KITTTITAS COUNTY COMMUNITY DEVELOPMENT SERVICES

December 29, 2020

Subject: Forest Ridge Phase 1 (LPF-20-00005) Final Long Plat – Staff Review and Request for Additional Information

LP-08-00014

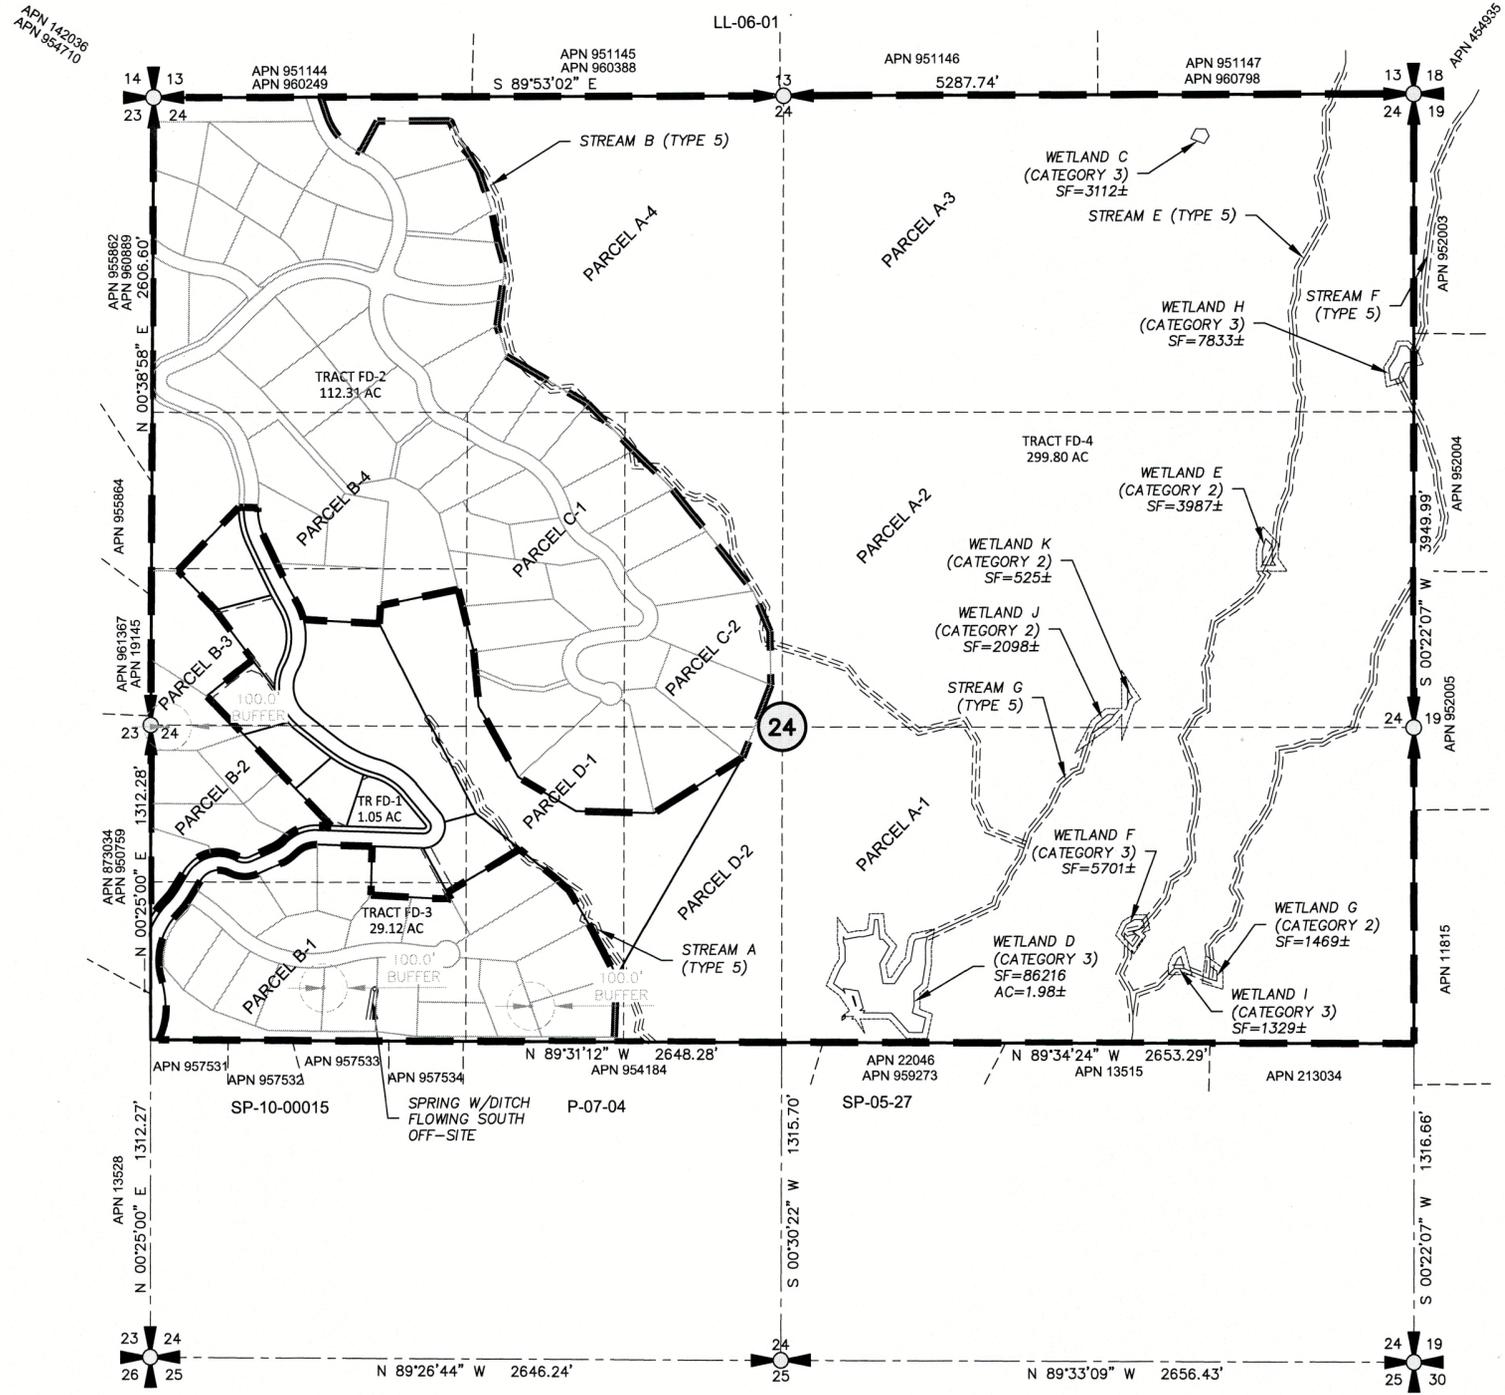
- Final mylars shall include the final plat number LPF-20-00005.
- Resolution 2010-137 Condition 8 states, "Prior to final plat approval, the applicant shall present to the County for review and approval a map demonstrating that at least 40% of the total plat area meets the open space requirements of Chapter 16.09." The condition compliance document provided notes that this map is included in the submittal materials, but staff could not locate this.

FOREST RIDGE - PHASE I PERFORMANCE BASED CLUSTER PLAT PREPARED FOR FRPP PHASE I, LLC A PORTION OF SECTION 24, TOWNSHIP 20 NORTH, RANGE 15 EAST, W.M.		
KITITAS COUNTY	WASHINGTON	
DWN BY T.S.	DATE 12/2020	JOB NO. 18069
CHKD BY M.K.K./D.L.P.	SCALE 1" = 100'	SHEET 5 OF 6

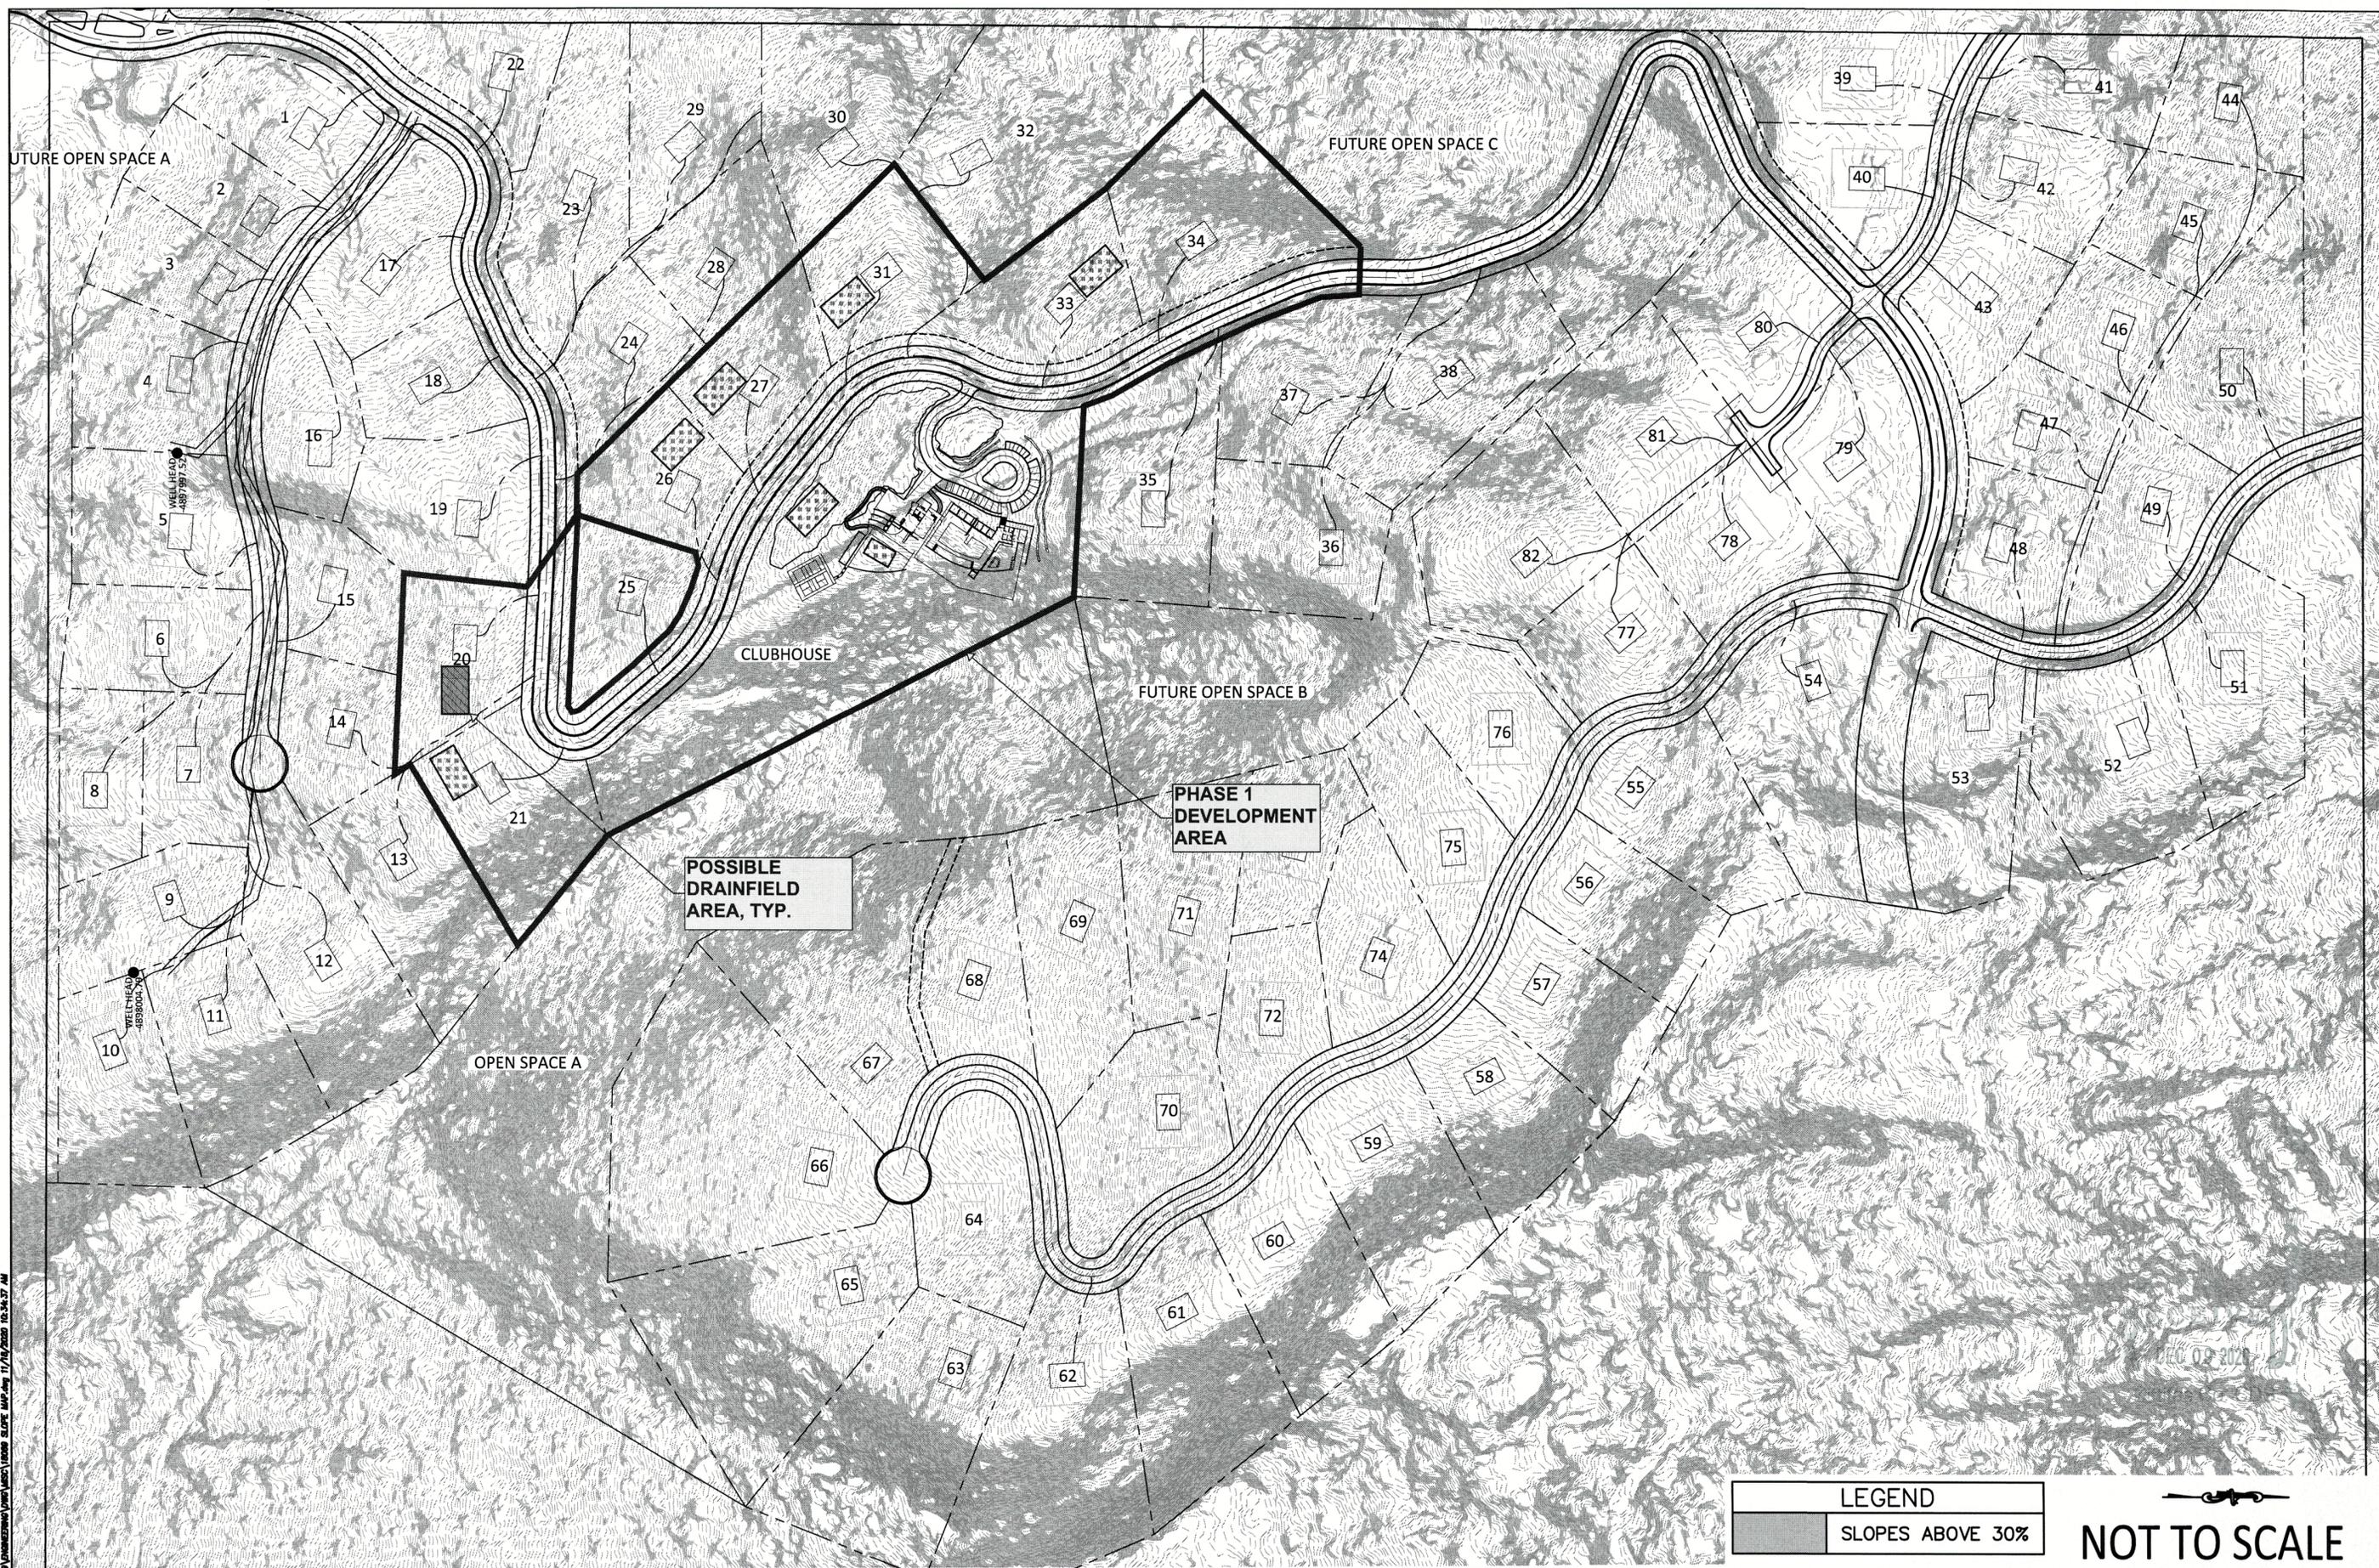
- Wetlands "A" and "B" as depicted on the attached wetland inventory map are not noted on the preliminary survey. Condition #11 of Resolution 2010-137 requires, "All wetland areas and their buffers shall be shown on the face of the final plat."
